Submissions Report

*Waterloo Metro Quarter -
Central Precinct (SSD-
79307746)*

March 2026

Prepared for: WL Developer Pty Ltd

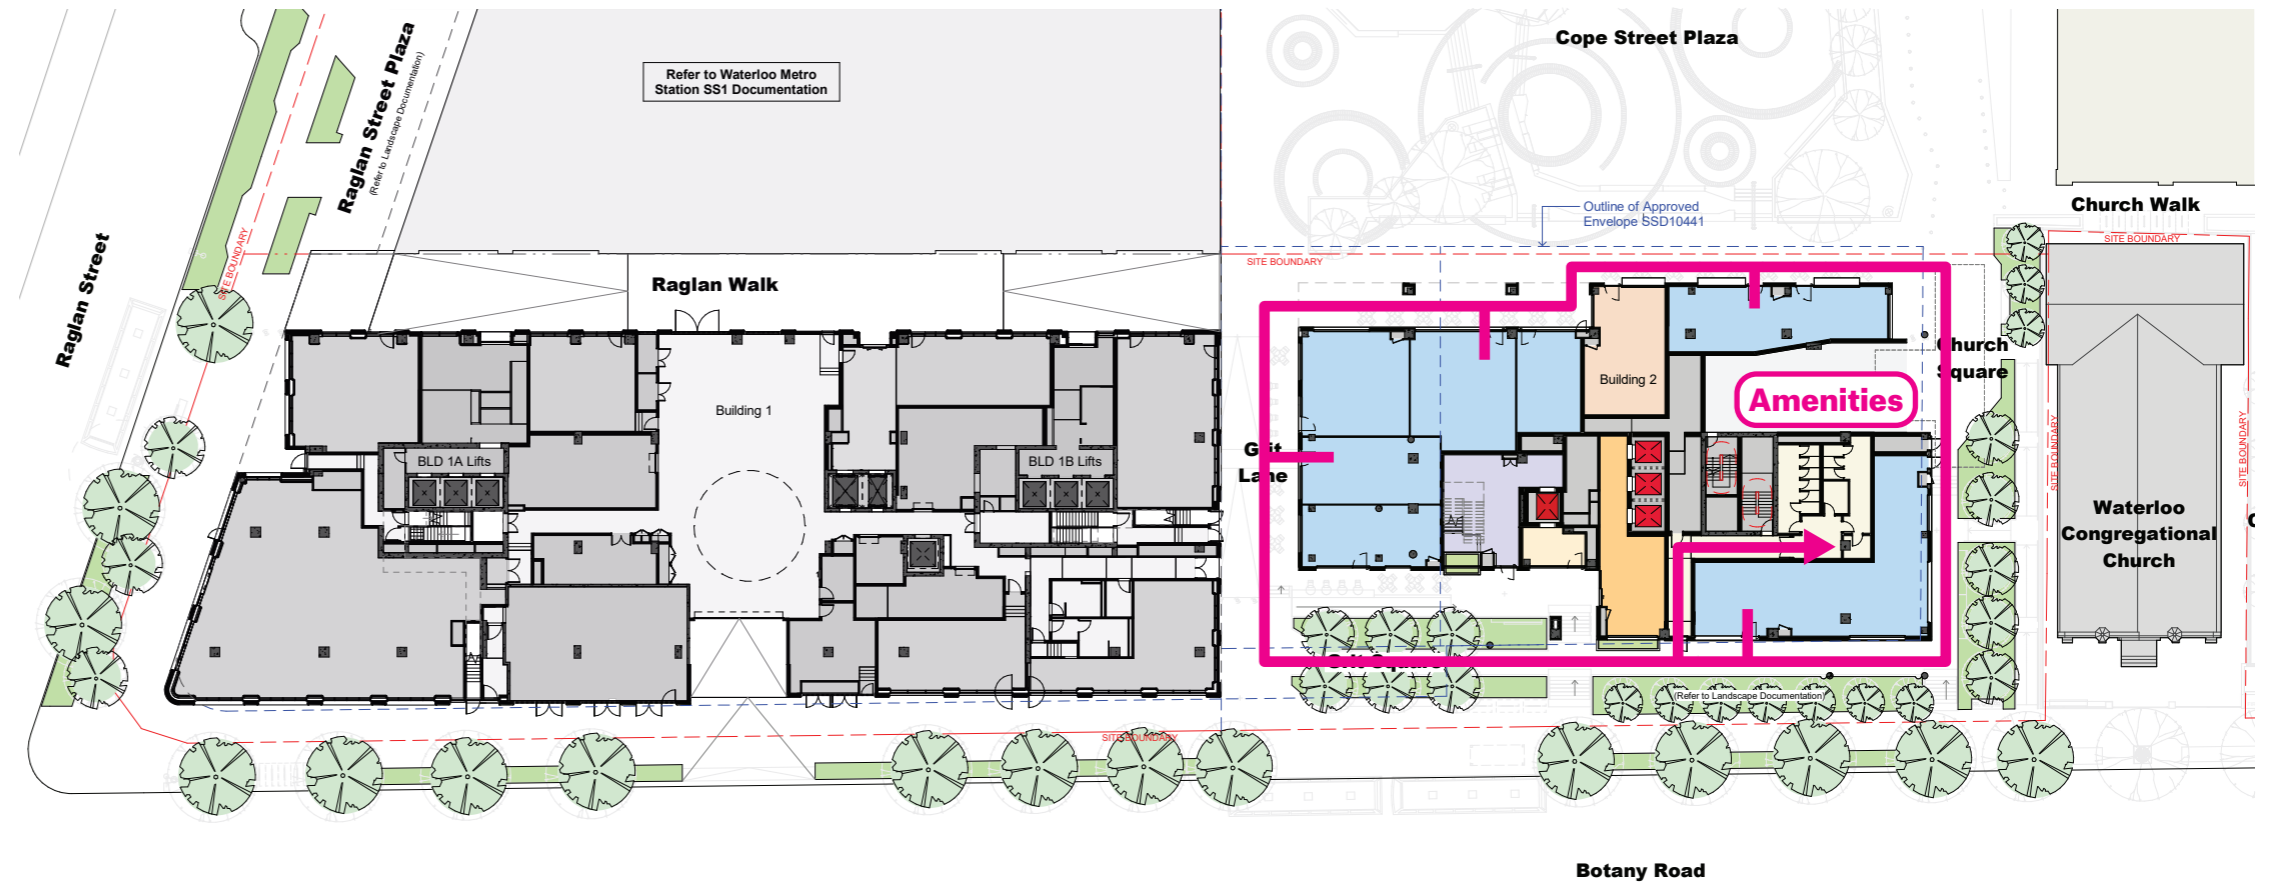
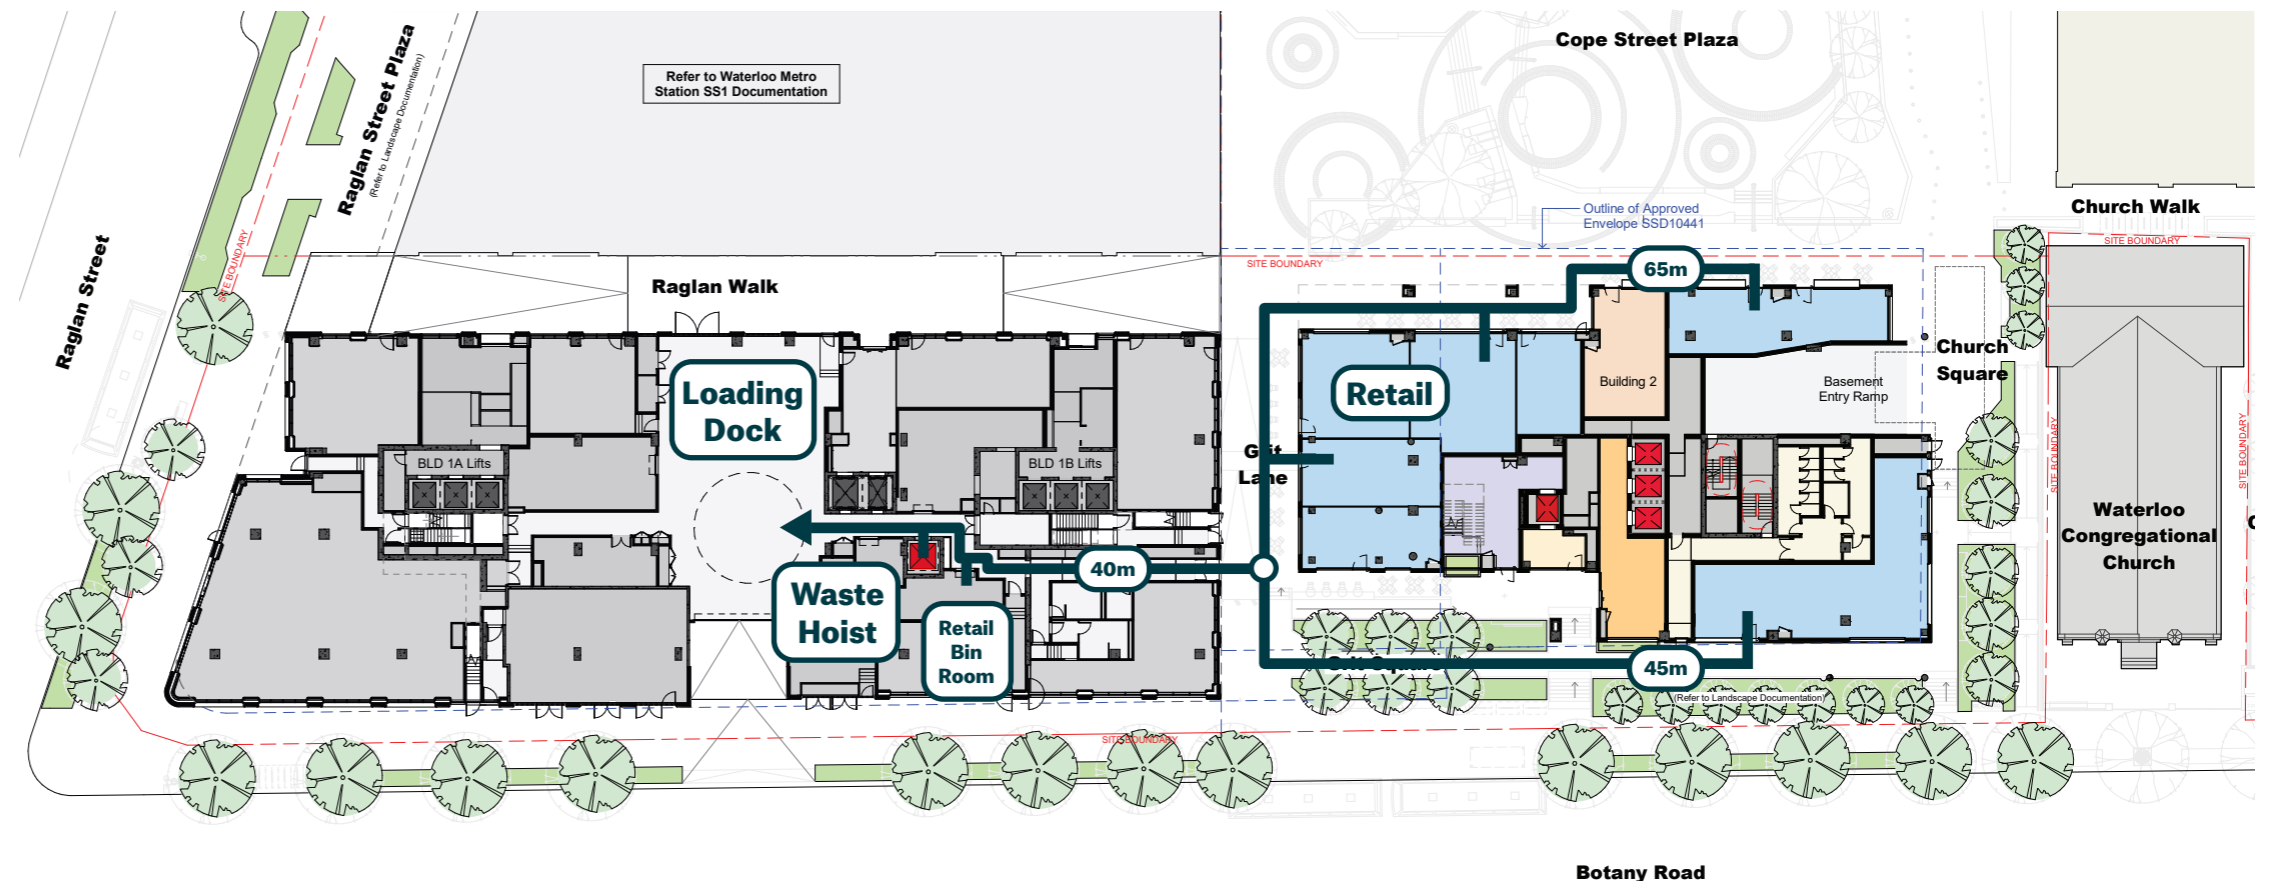
- Review the design of the ground floor / retail layouts of the Northern and Central Precinct to achieve equitable access to shared amenities / back of house areas; and

Address SDRP advice on Site Strategy and Built Form Point 8: Ensure that the serviceability of the retail offerings is considered during design development. For example, access to shared amenities, ventilation requirements and kitchen exhausts

Ground level shared amenities for the Central Precinct are centrally located to ensure convenient and equitable access for all retail tenancies. The location is separated from vehicular paths to promote pedestrian safety and the entrance benefits from clear visibility from the public domain.

All waste collections will occur onsite from the shared loading dock at ground level. Retail waste will be transferred at ground level between tenancies with a shared retail waste room located near the loading dock. An allowance has been made for three (3) 3000L/s exhaust risers serving the ground floor retail tenancies, providing capacity for future food and beverage uses.

Level 3 Roof Terrace Section

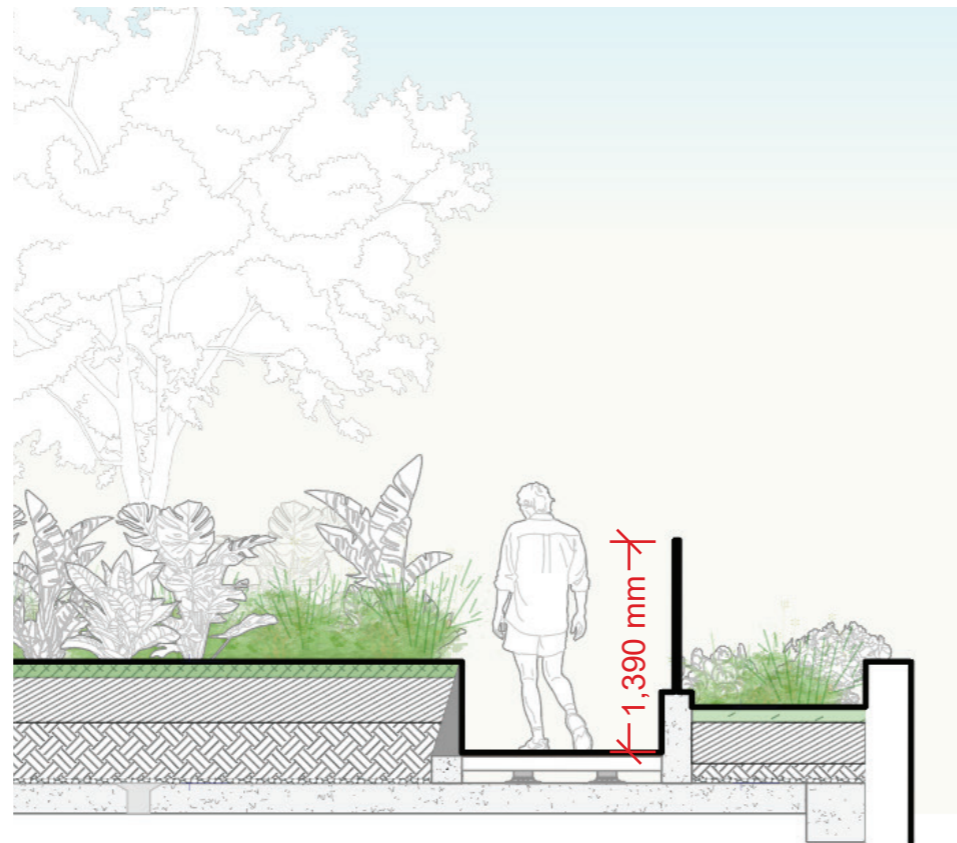
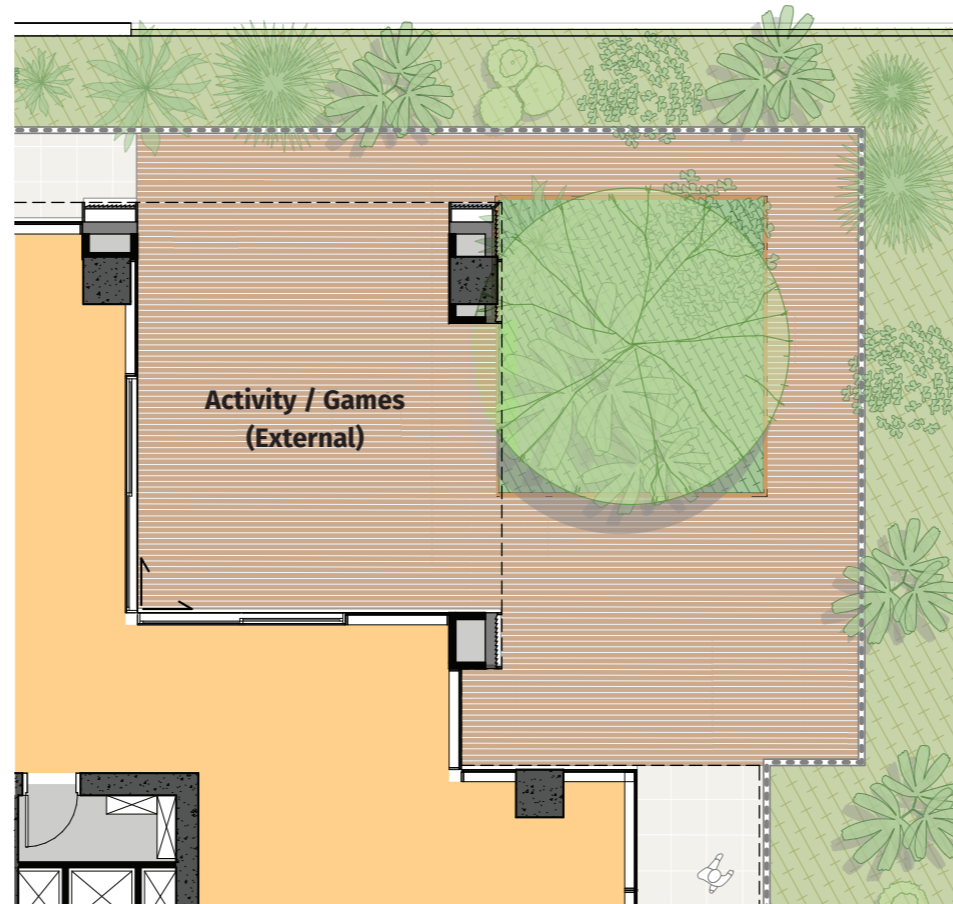
Issue Raised	Response	Appendix
Department of Planning, Housing and Infrastructure		
<i>Statutory Compliance</i>		
<p>Provide further details, including supporting documentation and drawings to illustrate how the proposal achieves consistency with the maximum gross floor area (GFA) permitted under the Concept Approval. This must include how the proposed exclusions (such as the Level 1 and 2 Childcare outdoor play areas, and the Level 3 communal areas) in the Central Precinct meet the definition of GFA under the Sydney Local Environmental Plan 2012 (Sydney LEP).</p>	<p>The accompanying Supplementary Design Report prepared by Bates Smart identifies the areas excluded from the Building 2 GFA. These areas are located on the external terraces of the childcare centre at level 1 and level 2 and relate to planters that are immediately adjacent to 'openings' within the external wall. The openings are covered by porous mesh screens resulting in the adjacent areas being open to the elements.</p> <p>The planters have a height of less than 1.4m. Accordingly, these areas have been excluded from the calculation of GFA.</p> <p>The outdoor Level 3 communal area does not comprise GFA and has been excluded from the GFA calculation under subclause (i) of the GFA definition in the Sydney LEP.</p>	<p>Appendix B – Supplementary Design Report</p>

Overall, the total GFA across the Southern, Central and Northern Precincts is 68,747sqm. The total GFA is below the approved GFA under the Concept SSD, which is 68,750m² excluding station floor space. The FSR for the overall WMQ development remain below 6:1. Accordingly, the second amending concept proposal remain compliant with the approved GFA for the OSD.

**Pedestrian Wind Comfort Conditions at Level 03**

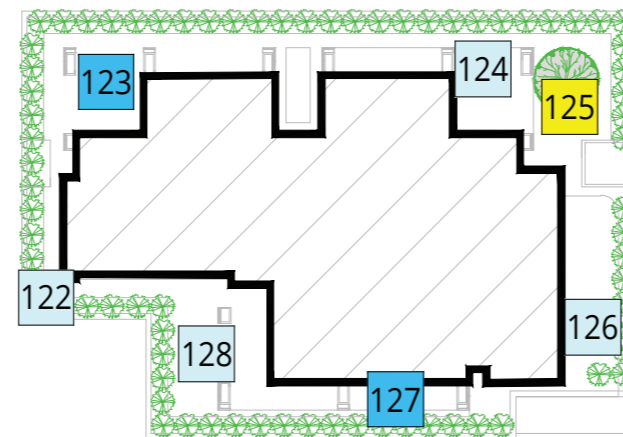
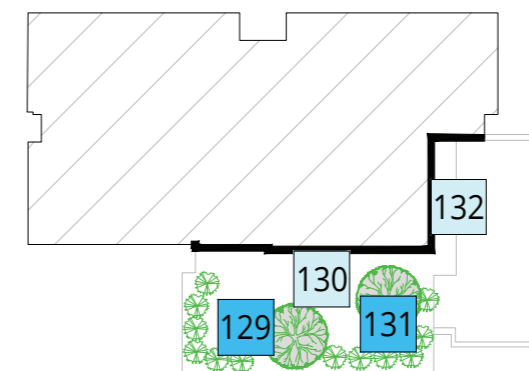
-
- B. A standing criteria for Grit Lane between Botany Road and the southern station entrance (Sensor locations 25, 50 and 52)
 - C. A standing criteria for the corner of Botany Road and Raglan Street (Sensor locations 59, 60 and 62)
 - D. A sitting criteria for podium and rooftop spaces where outdoor seating / dining and kitchen / study areas are proposed (Sensor locations 124, 125, 128, 129, 130 and 131)

The final built form tested was the result of the above iterative design collaboration and provided a positive outcome for the precinct. The design was observed to achieve the required criteria from the Design and Amenity Guidelines with only the built form massing for majority of the areas.
